## Fw: AC Hotel - Thames Street Sidewalk

Attached are my responses to your comments regarding the ramp and sidewalk seating. Please review and then lets talk.

We talked about this just now, and folks had the following comments:

GRADING, DRAINAGE AND EROSION CONTROL PLAN

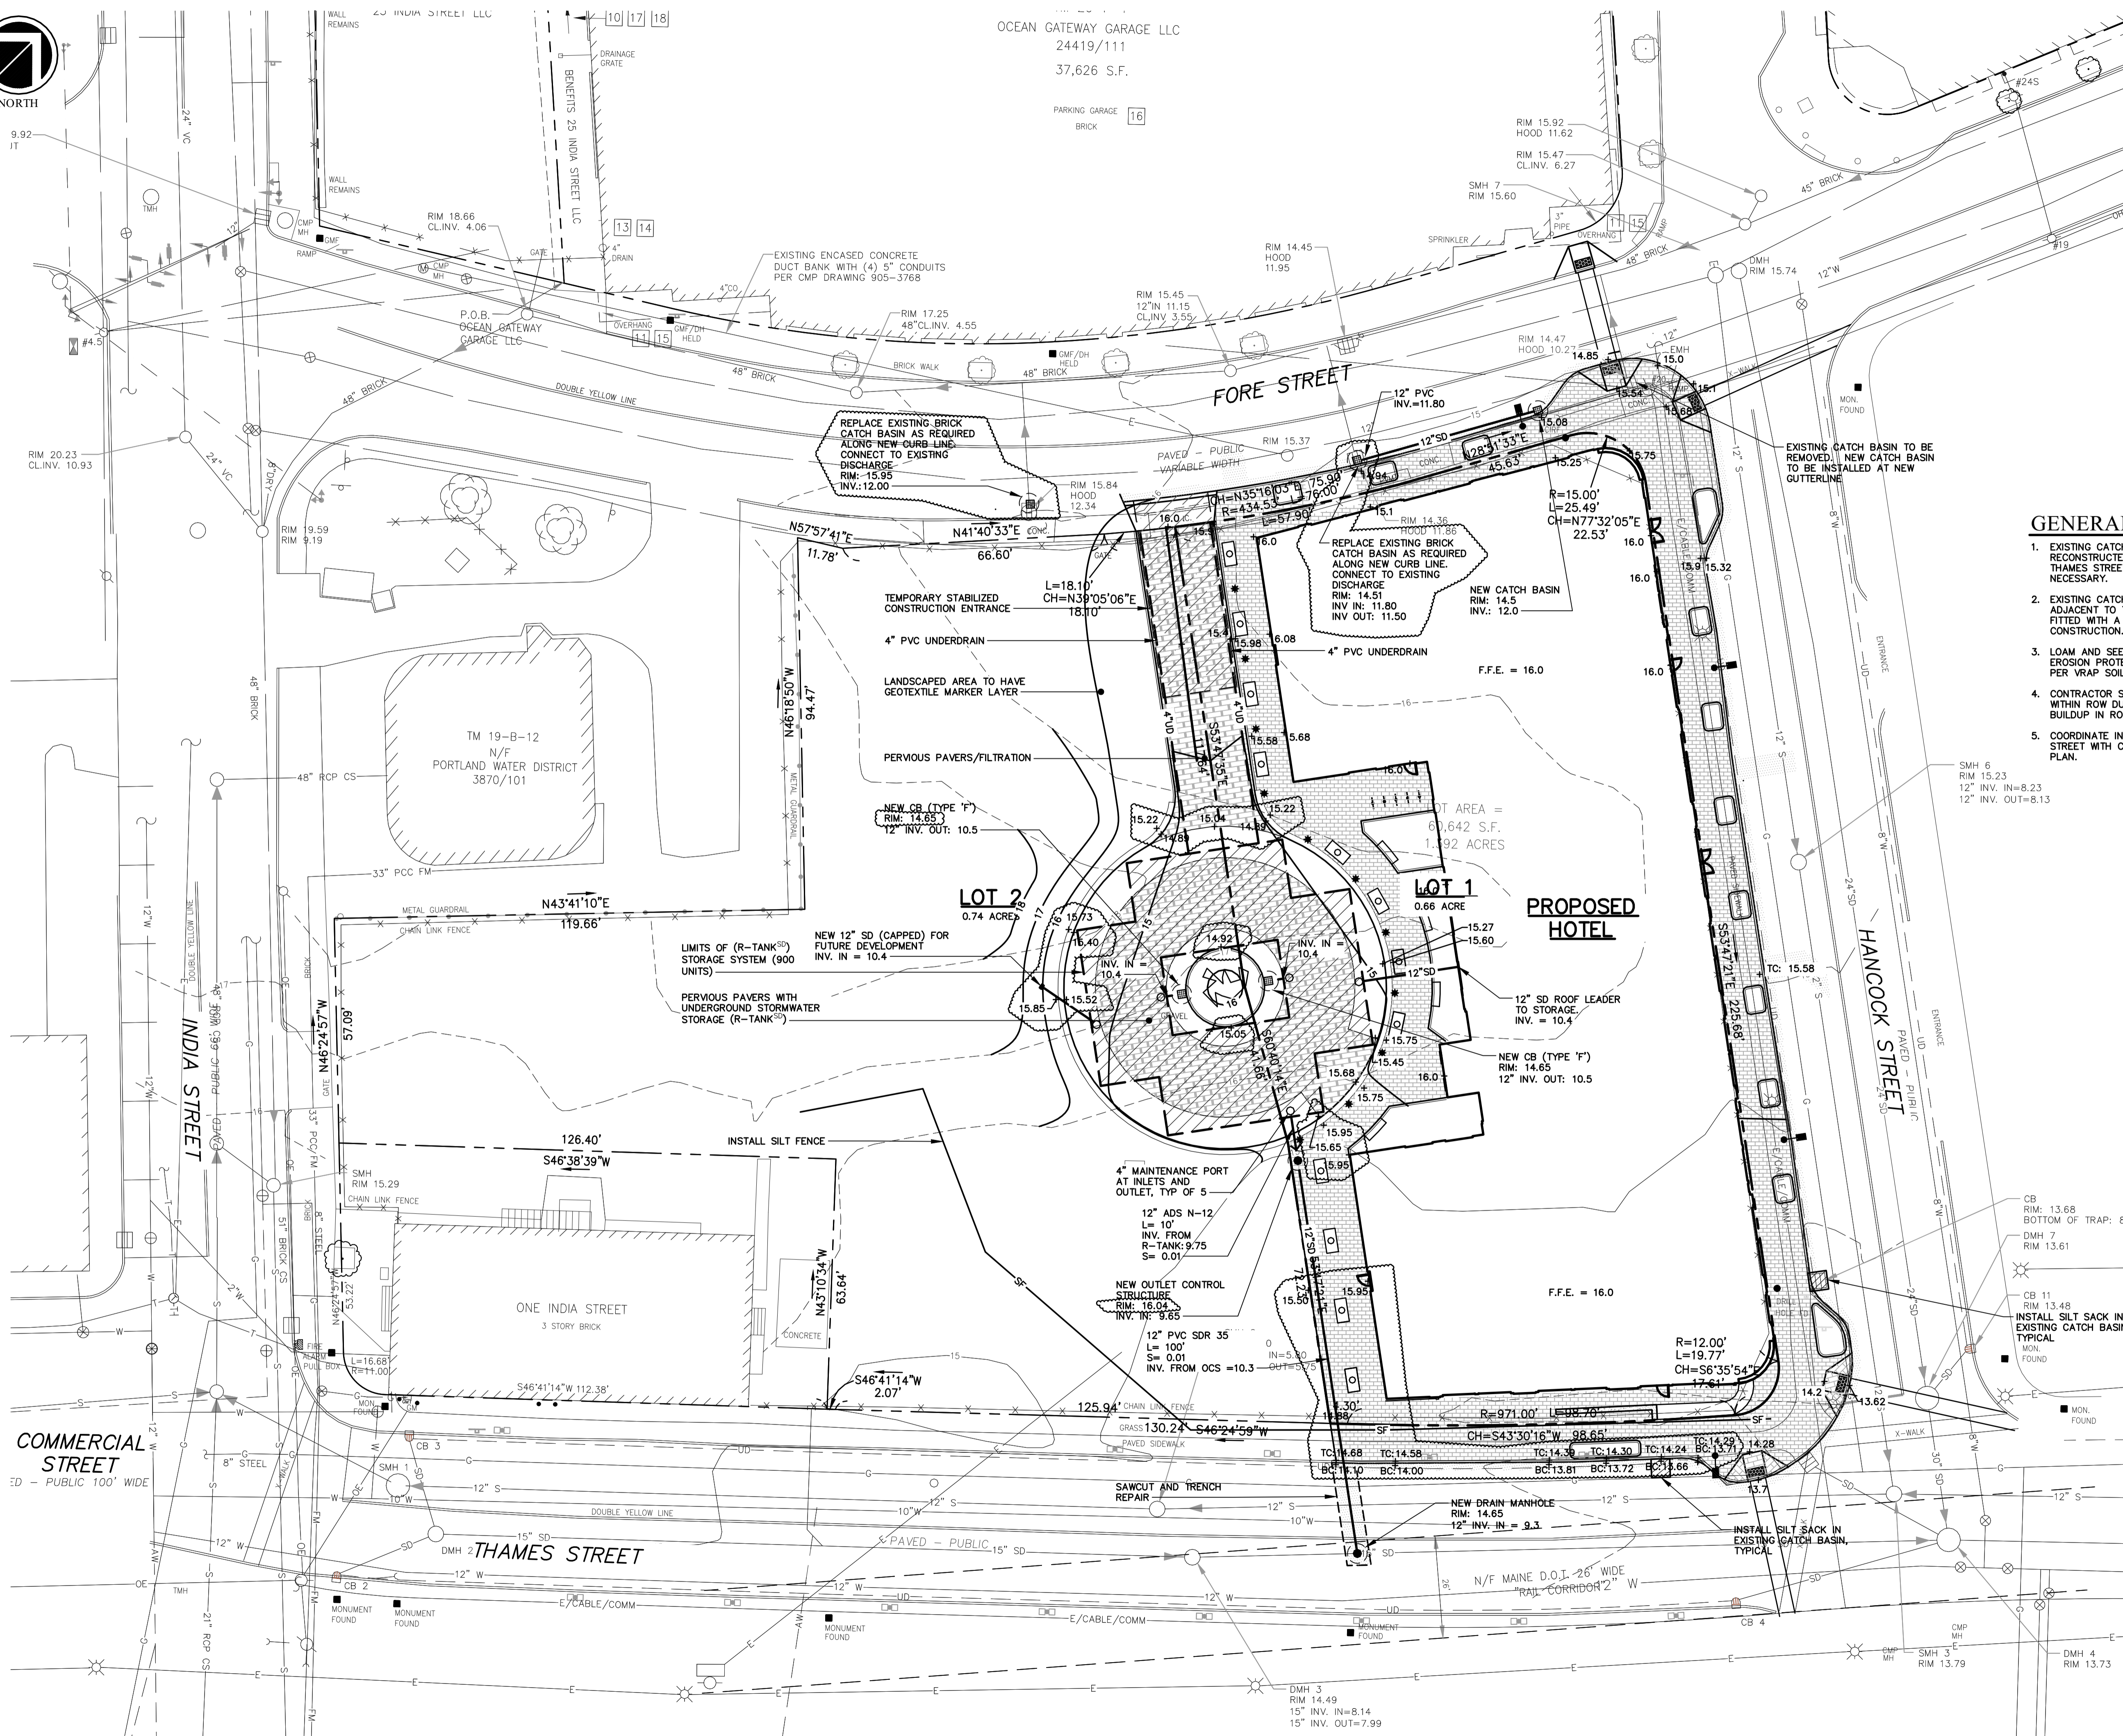
- There's some concern about the ramp function when outdoor seating is in use. Can you wrap the seating area around the westerly corner of the building and open up the entry to the ramp? **The ramp functions to provide an accessible route from Thames St up to the main entrance doors at the corner. We anticipate minimal use of this ramp, as the broad steps that wrap around the corner will really function to provide egress for most visitors. The enclosed seating currently allows a 4 ft access aisle from the sidewalk to the base of the ramp, this could be slightly widened (from 4 ft to maybe 5-6'?) to feel more generous but don't want to compromise the ability to provide adequate outdoor seating. The seating area can be expanded around the corner to some extent, (+/- 6-8 ft), but we need to insure that corridor remains accessible for emergency vehicles.**

- On the revised plans, we need to show the modified ramps at the corner(s). **Agreed, this sketch was focused on the entrance/ ramp/ outdoor seating. The corner will remain as previously designed/ permitted.**

1 STREET TREE + LIGHTING PLAN

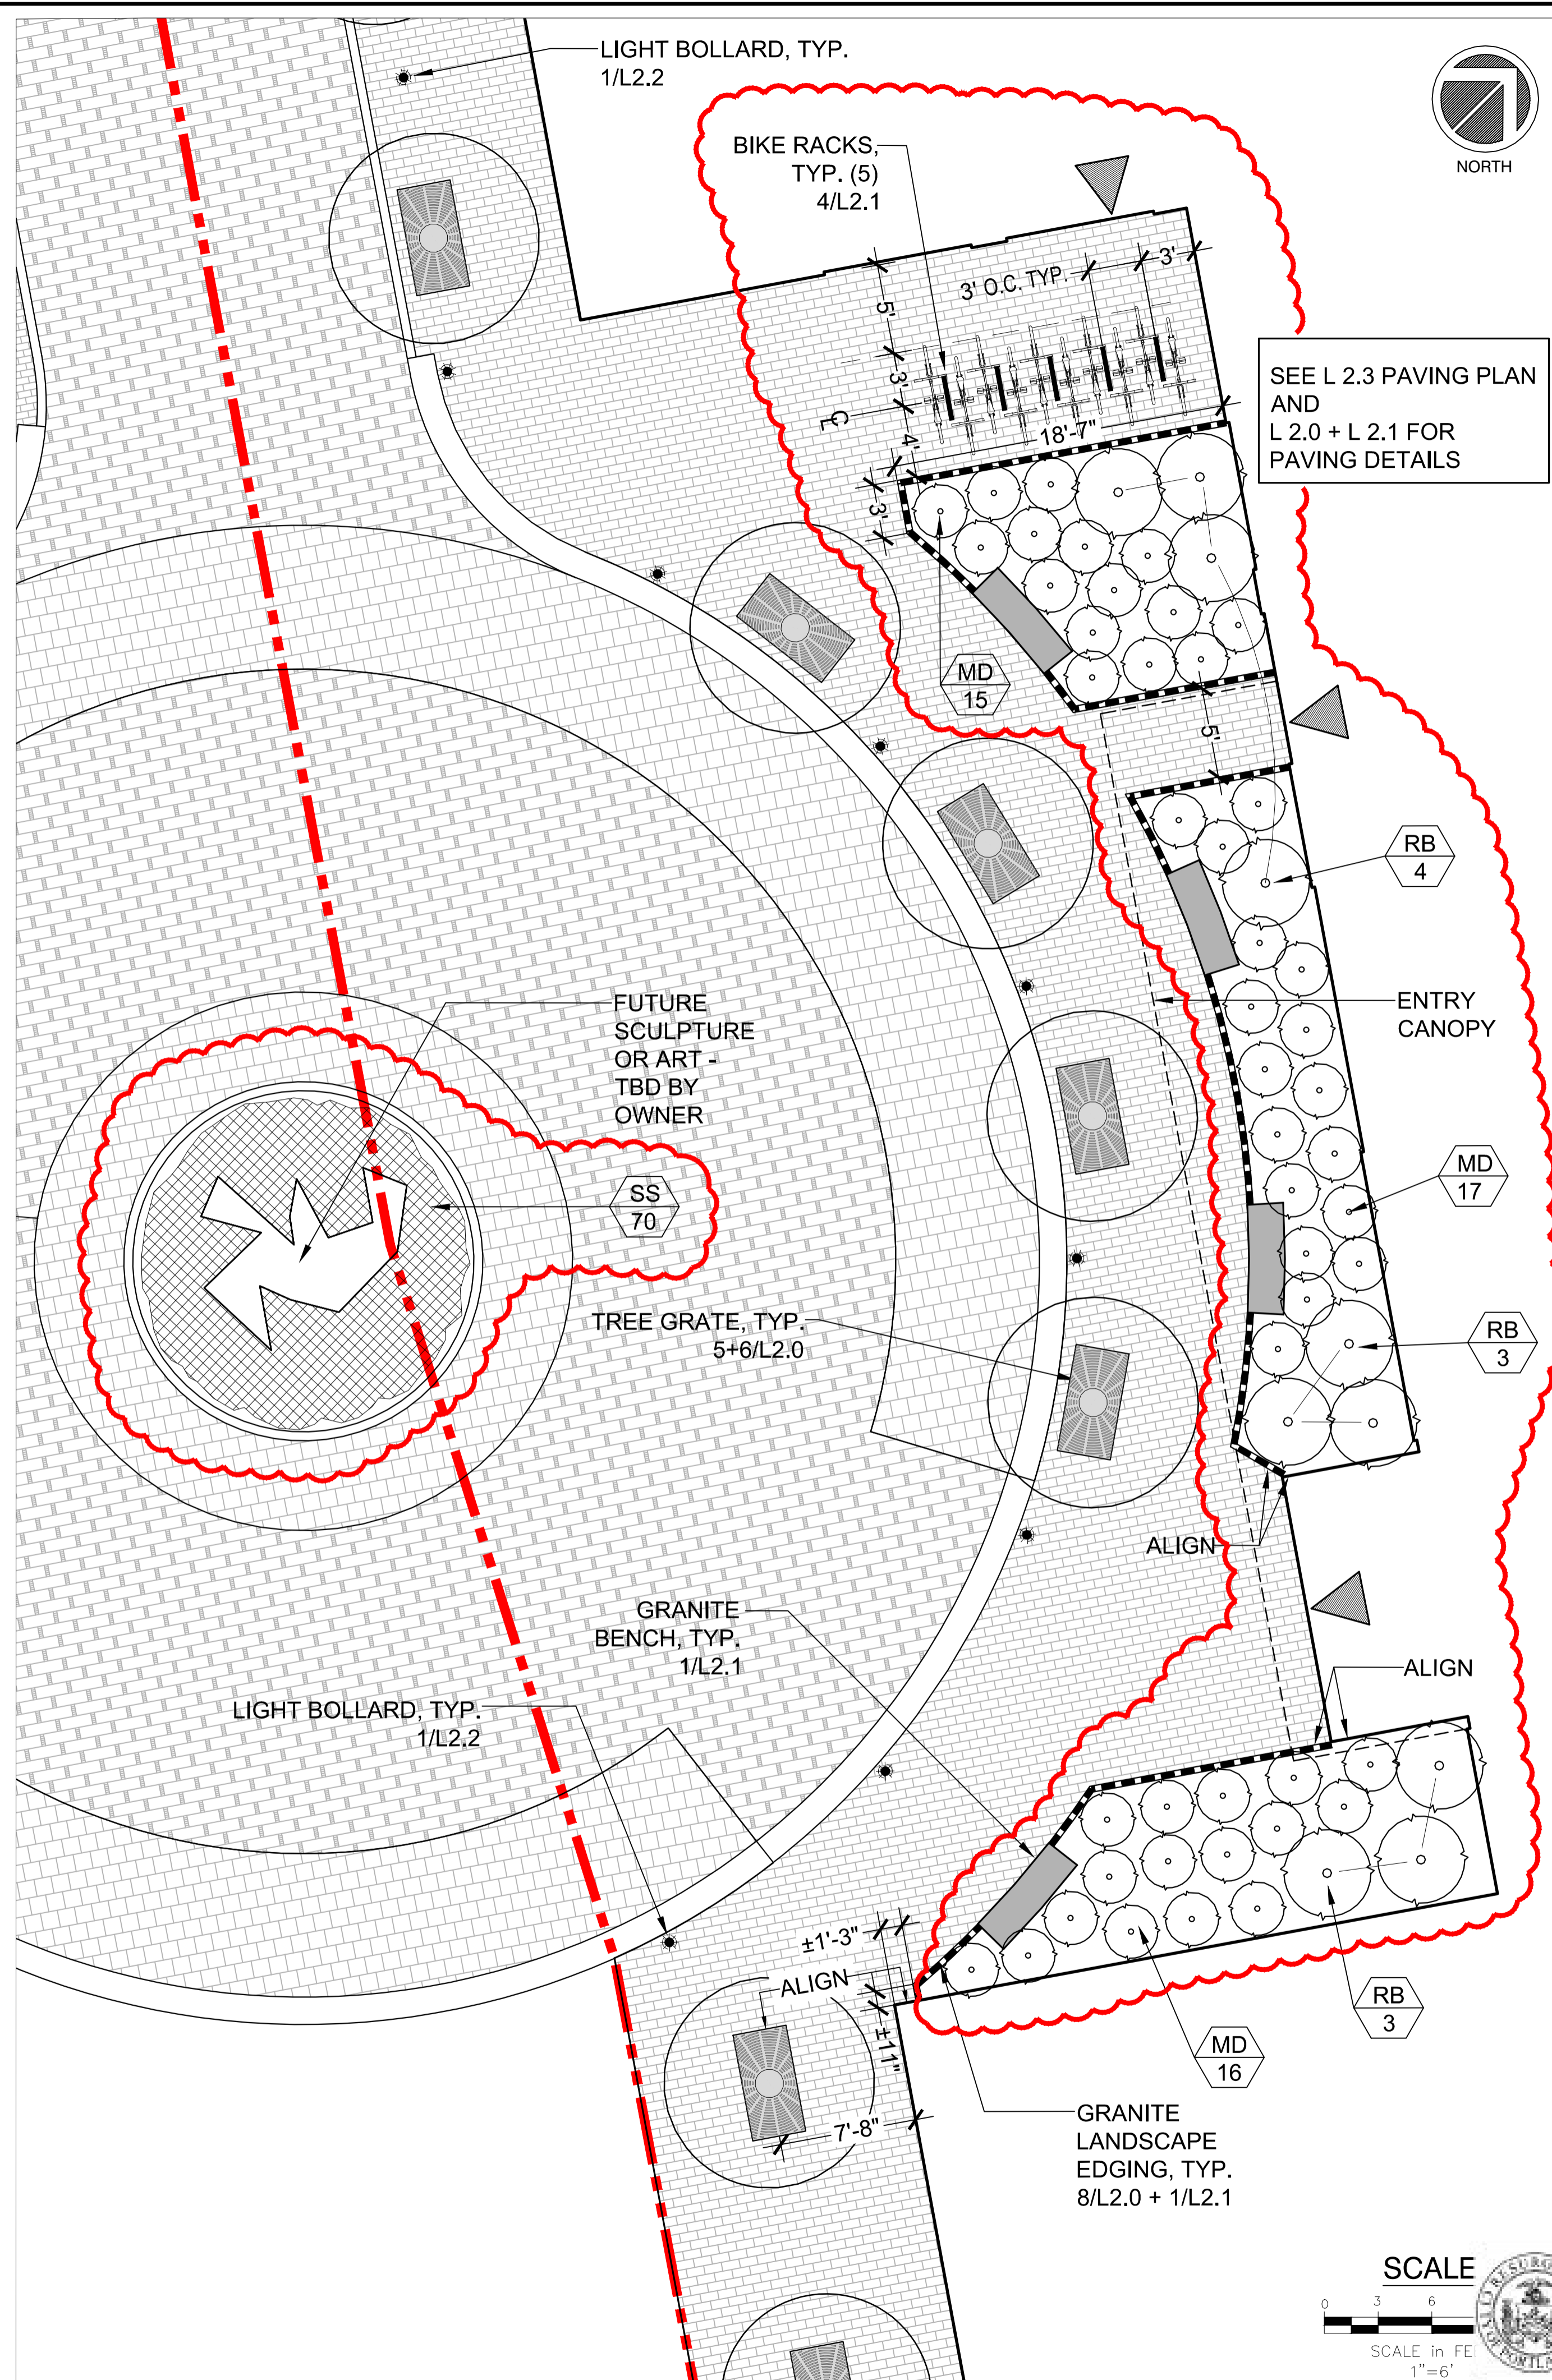
- We need to know dimensions (e.g. how much clearance is there from street tree boxes to edge of curb?). We'd like to maintain as close to 8 feet there as possible. **There is a minimum of 5ft of clear sidewalk where the tree boxes are located and 8-9 feet along the other parts of the public sidewalk. This is consistent with the sidewalk dimensions along Fore and Hancock St Extension, as well as what was previously approved along Thames Street when the trees were located along the curbline. We basically just flipped the tree boxes from the curbline to the backside of the r.o.w. The outdoor seating is anticipated to extend to the outer face of the tree box, maintaining 5 ft of clearance, which is allowed by ordinance.**

- Is there a way to put the two easterly trees in the planter? **The planter is too narrow in width to support a tree planting and it would conflict with the overhead canopy that extends along this face of the building.**

- The tree boxes should have the rounded corners that Jeff Tarling is now requesting. **We are exploring the idea of raising the tree boxes up approximately 18" to provide a stronger design element that ties into the planter and fencing associated with the outdoor seating area. I will provide a sketch soon for this planter element.**
